Recommendation Report for Planning Permission for Works or Extension to a Dwelling

REF NO: FG/1/26/HH

LOCATION: 8 Laburnum Close
Ferring
BN12 5EJ

PROPOSAL: Proposed front extension (to replace existing porch/conservatory), rear extension, new roof tiles and render to cover existing brickwork and loft conversion to include front and rear dormers and removal of barn hips to the side.

PROPOSED FRONT / REAR EXTENSIONS AND LOFT CONVERSION

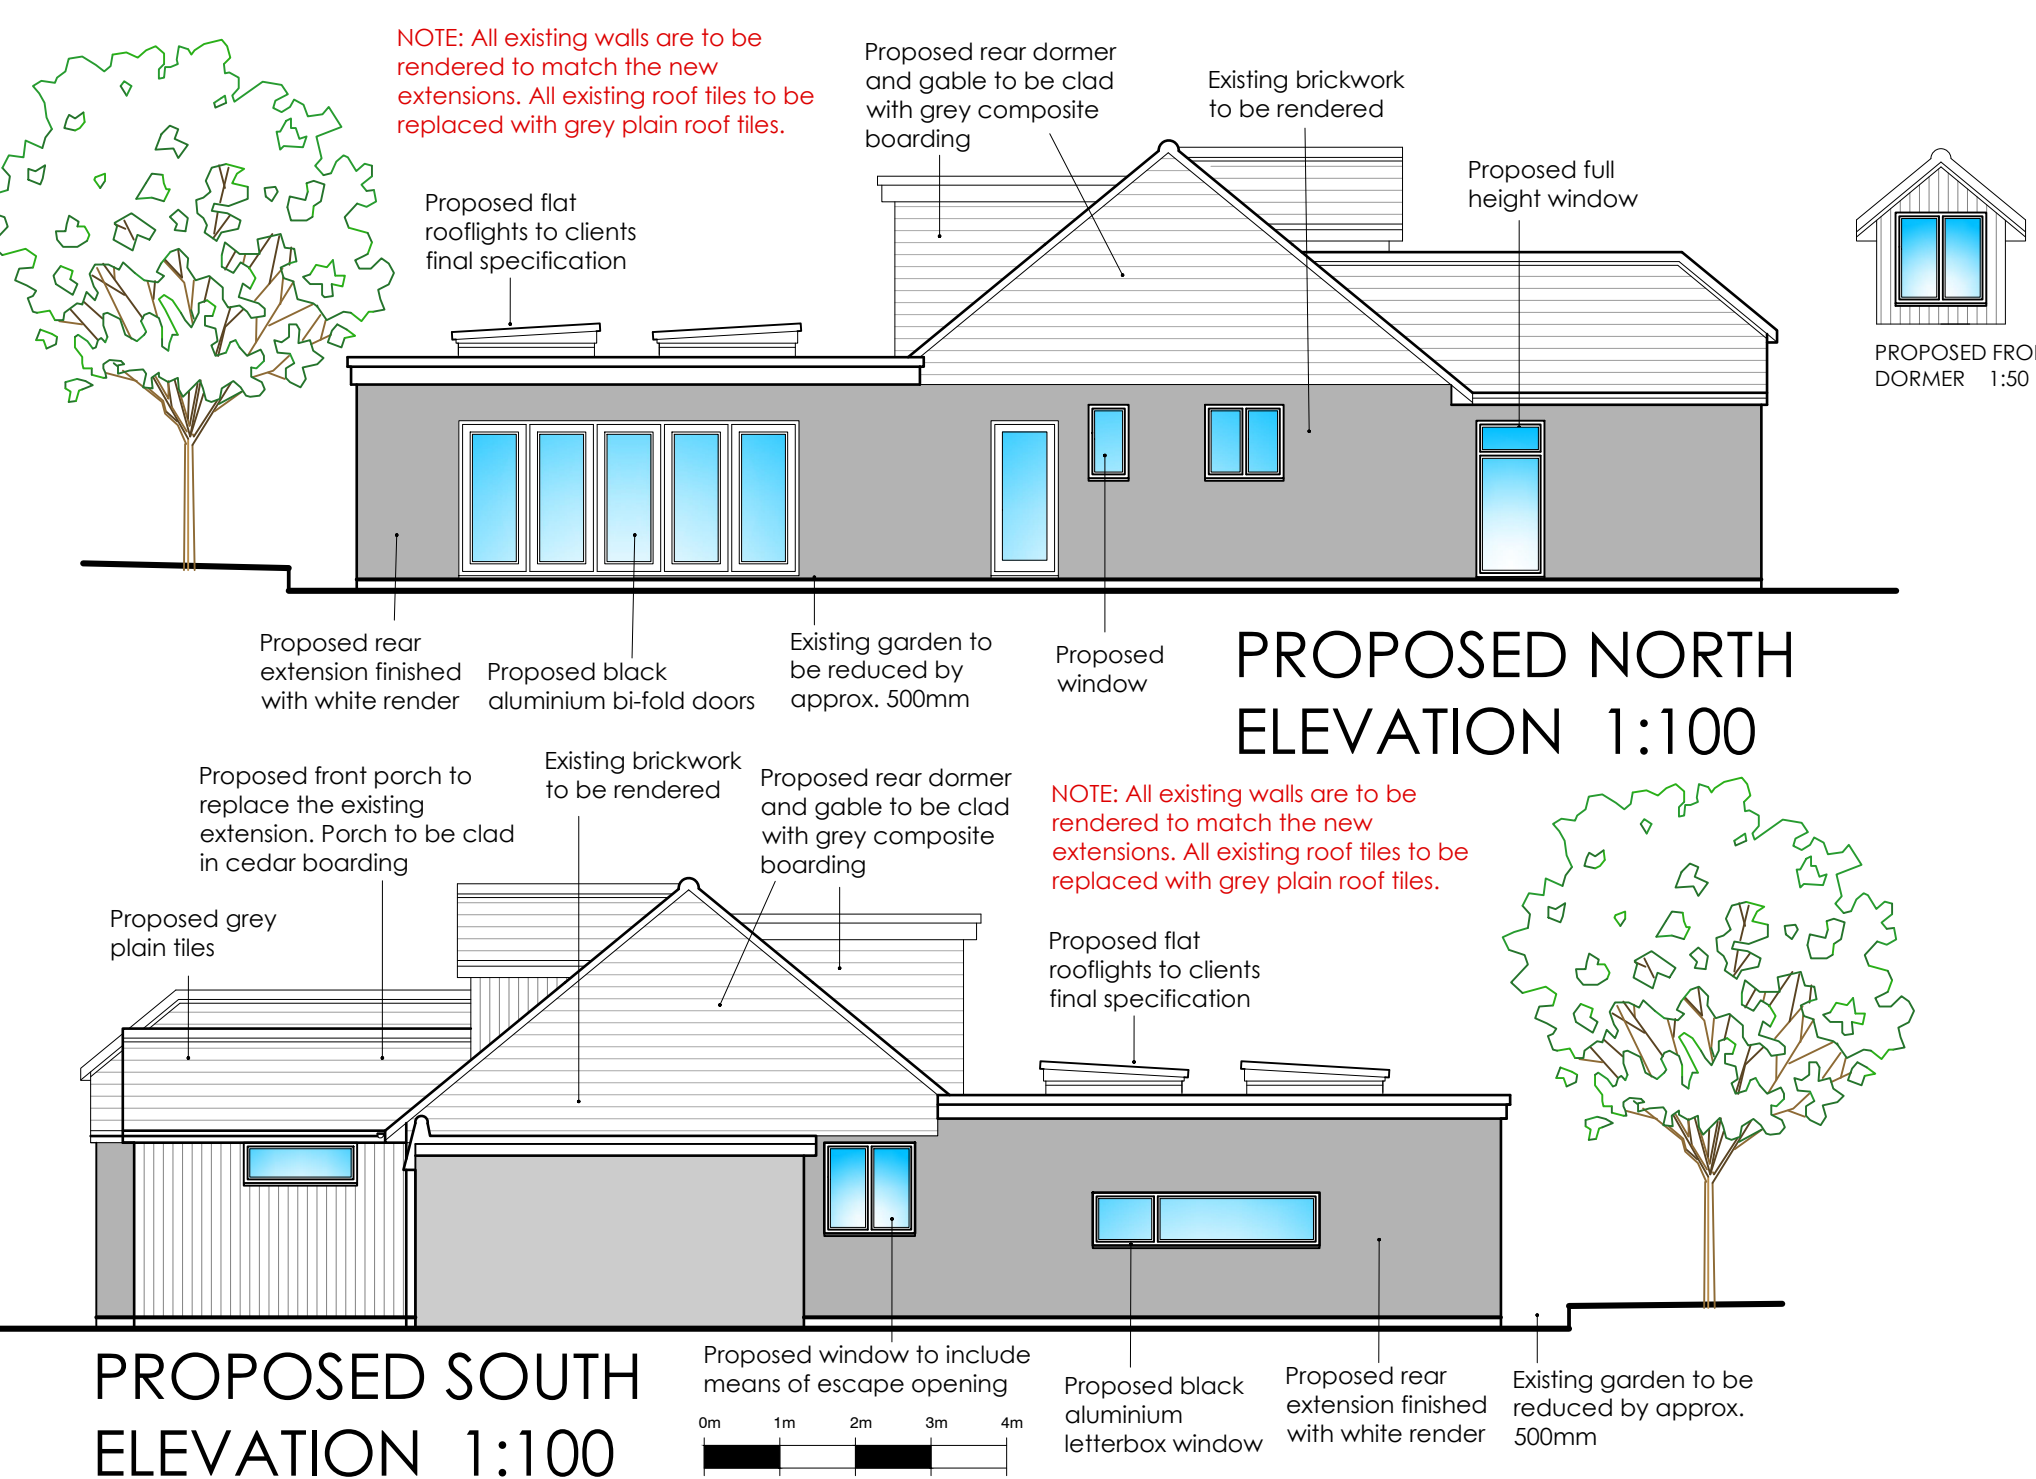
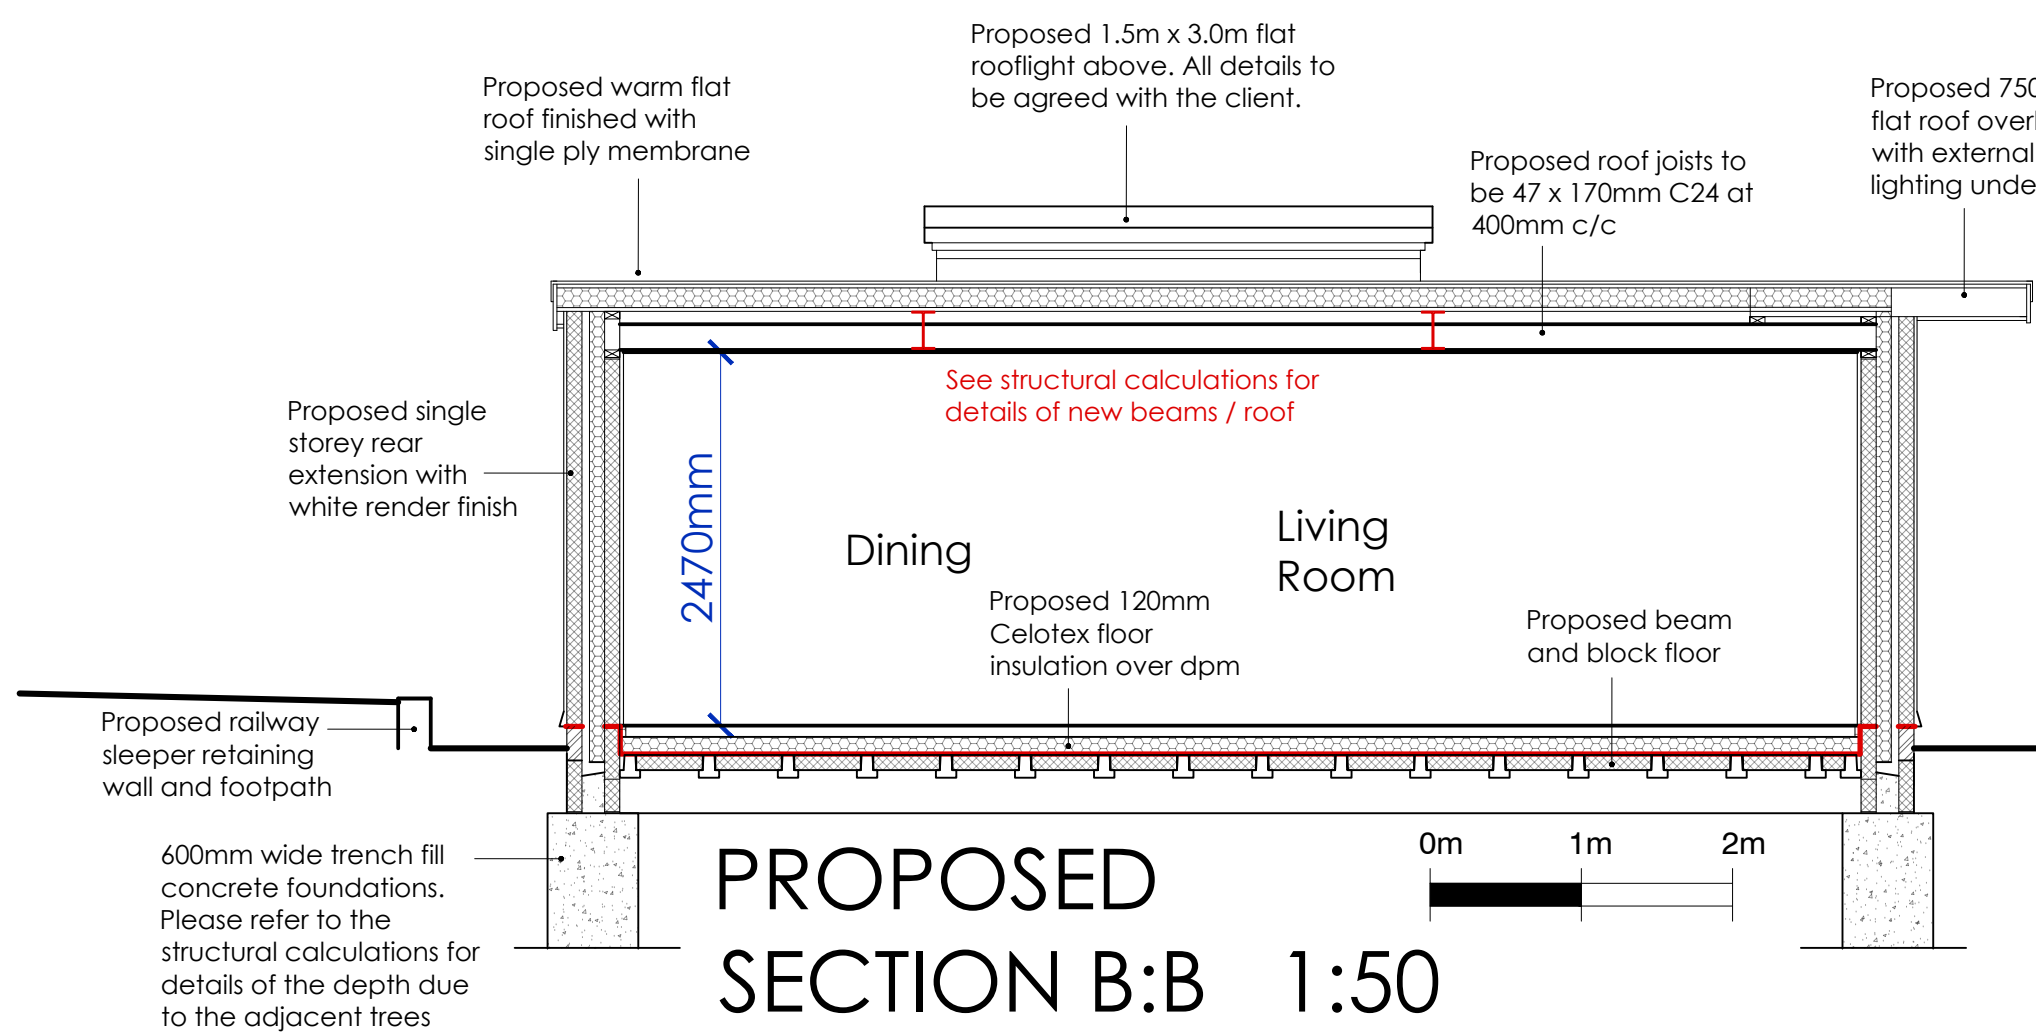
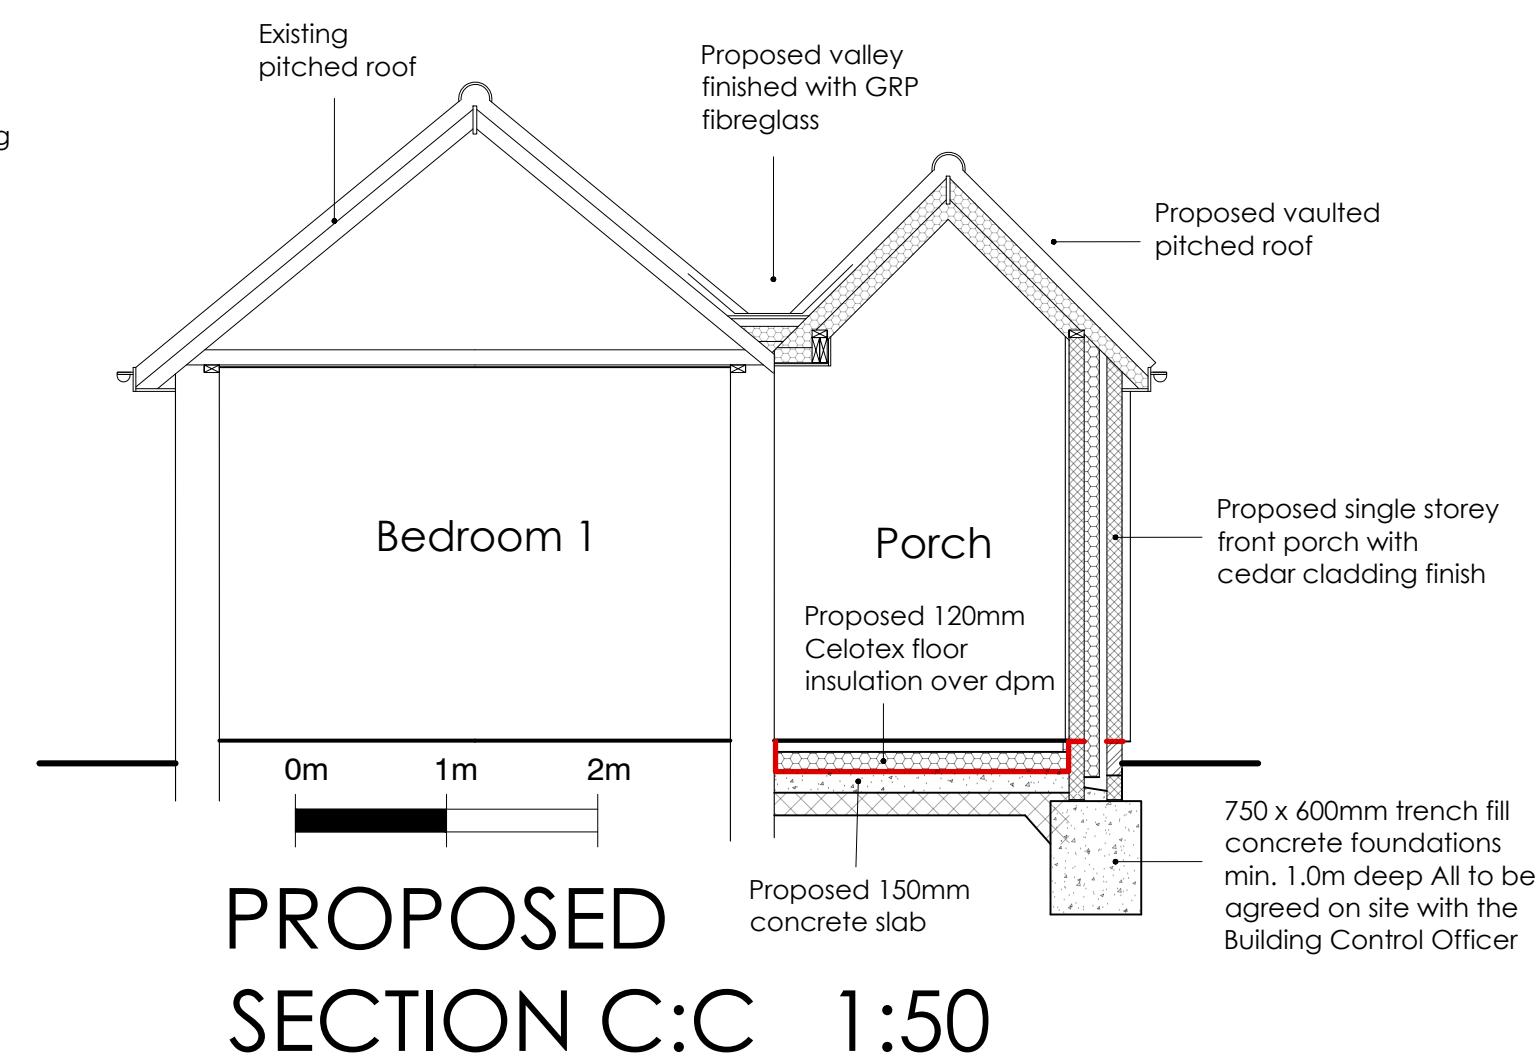
Roof alterations are proposed to convert the loft to habitable space. The existing barn-hipped roof sections would be raised to full gables, aligning with the existing ridge height of 5.9m (from existing eaves height of 4.4m at the barn-hip ends). New dark grey roof tiles are proposed. It is noted that there are no other properties with gabled roof forms within the street scene, however, this alteration could be constructed under permitted development, and it is acknowledged that there is some variation within the street scene with regards to hipped and barn-hipped roof forms. As such, the proposed roof extensions would not result in demonstrable harm to visual amenity.

A small front dormer is proposed on the front (west) elevation, featuring a pitched roof consistent with the existing front projection and new front extension. The dormer would measure approximately 1.7m in width and 2.9m in depth, with a maximum height of 2.3m and an eaves height of 1.1m. It would be finished in cedar boarded cladding and contain a two-pane window. The dormer would be a subservient addition to the front roof slope, and would not appear overly dominant despite there being no other examples within the street scene. As such, given the scale and design of the dormer, the dormer would be acceptable within the context of the site.

A rear dormer is proposed within the rear roof slope elevation, facing east. The dormer would measure approximately 8.2m in width and 3.3m in depth, with a flat roof reaching 2.4m in height. It would be finished in grey composite cladding to complement the proposed roof tiles and would feature two three-pane windows. The rear dormer would be large in scale, and would not be subservient addition within the rear roof slope. The eaves line of the original roof would not be reinstated, and the proposed dormer would instead adjoin the flat roof section of the rear extension. However, it is noted that a rear dormer of comparable scale and volume could be constructed under permitted development, and given the siting of the dormer to the rear, the dormer would not result in demonstrable harm to visual amenity.

External materials and finishes would include cedar board cladding to the proposed front dormer and front extension, with white render to the remainder of the host dwelling. While these materials would not reflect the existing character of the property or the wider street scene and therefore would not fully comply with the ADG, there is some variation within the street scene, with render present and a small proportion of the dwelling would comprise cladding. As such, the material change would not result in undue harm to visual amenity and would be acceptable in this instance.

Windows within the side (south) elevation would be at ground floor level and benefit from screening by the existing 1.8m high boundary fence. These openings would therefore not result in overlooking or loss of privacy to the neighbouring property to the south. The ground floor rear fenestration would look onto the private rear garden and would be adequately screened by the existing boundary treatment and mature vegetation. The new ground floor side facing openings on the northern elevation would not result in any harmful overlooking or loss of privacy due to the significant separation distance, reinforced by the presence of a public footpath and a 1.8m high boundary fence.

At first-floor level, the proposed dormer in the rear (east) elevation would introduce new openings that would provide some views of neighbouring gardens, and as such, would result in some degree of overlooking. However, due to the positioning of the dormer, the windows would not directly overlook any habitable room windows of the neighbouring property. In addition, a dormer of this scale could be constructed under permitted development, and the proposed dormer would not therefore result in unacceptable overlooking.
